Ribble Valley Borough Council
By email

Your ref 3/2021/0275
Our ref DC/21/1403 v10
Date 19-JUN-24

Location: Land behind The Dog Inn, Market Place, Longridge PR3 3RR
Proposal: Proposed erection of 9 new dwellings and associated works

DRAINAGE - *REQUEST FOR FURTHER INFORMATION*

Section along existing drain

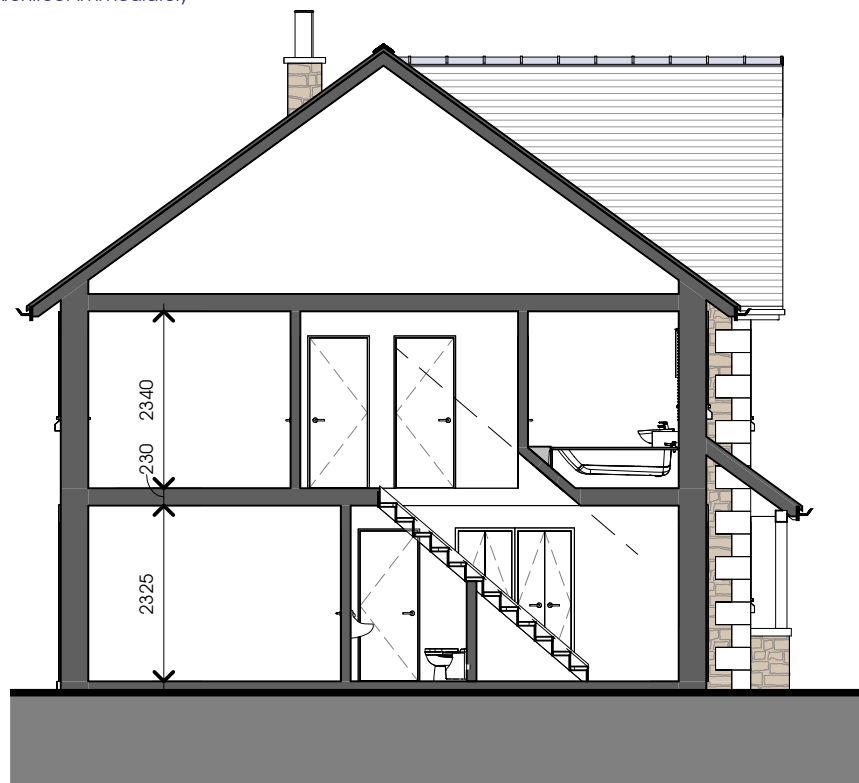
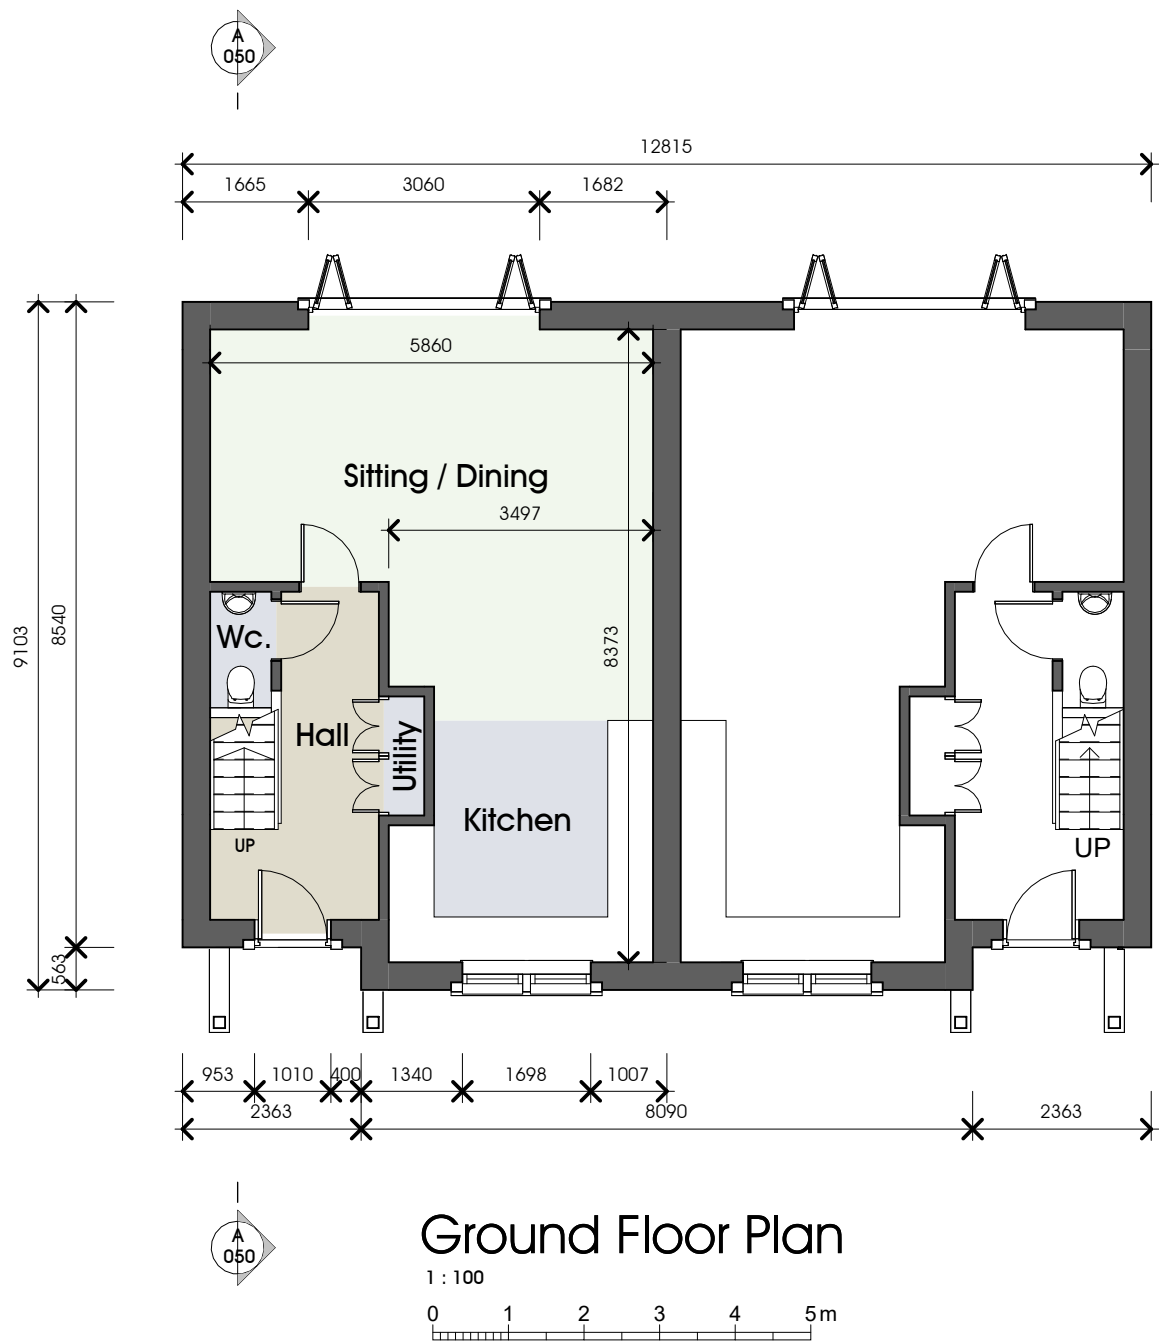
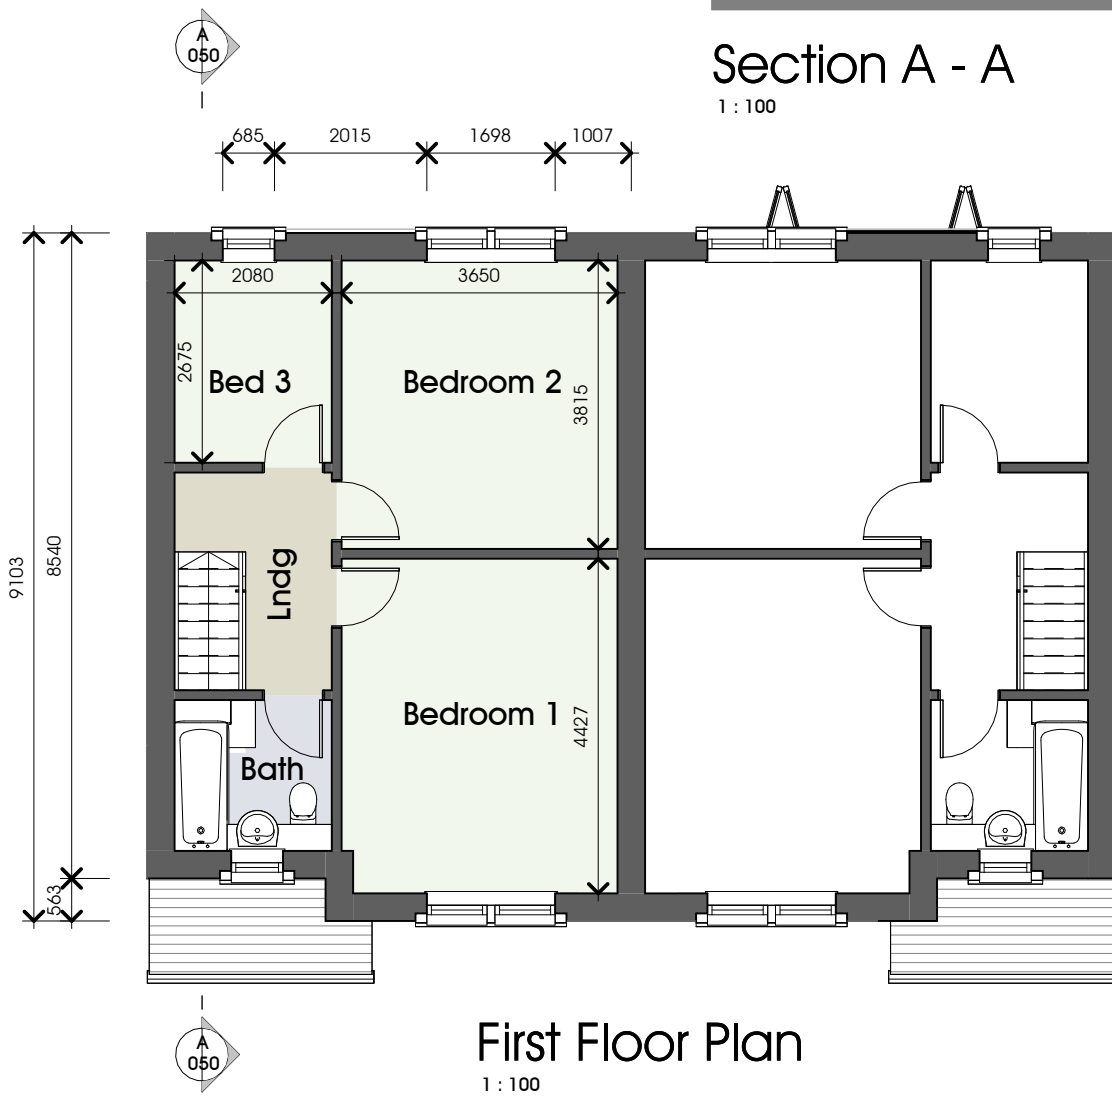
A public sewer crosses the site and we may not permit building over it. We require an access strip for maintenance or replacement. The minimum distances that might be acceptable to United Utilities are detailed within Part H of the Building Regulations however, **we recommend the applicant determines the precise location, size, depth and condition of the pipeline as this is likely to influence the required stand-off distance from any structure and could impact upon the proposed site layout.** We would like to draw the applicant's attention to further information contained in the Appendix to this letter, Section 2.0 'United Utilities' Property, Assets and Infrastructure'.

Should the Council deem this application suitable for approval, which is not our recommended approach at this time, we request the following condition is included in the subsequent Decision Notice to afford appropriate protective measures for the wastewater asset:

No construction shall commence until details of the means of ensuring the sewer that is laid within the site boundary is protected from damage as a result of the development have been submitted to and approved by the Local Planning Authority in writing. The details shall outline the potential impacts from construction activities and the impacts post completion of the development on the sewer that crosses the site and identify mitigation measures to protect and prevent any damage to the pipeline both during construction and post completion of the development. Any mitigation measures shall be implemented in full in accordance with the approved details.
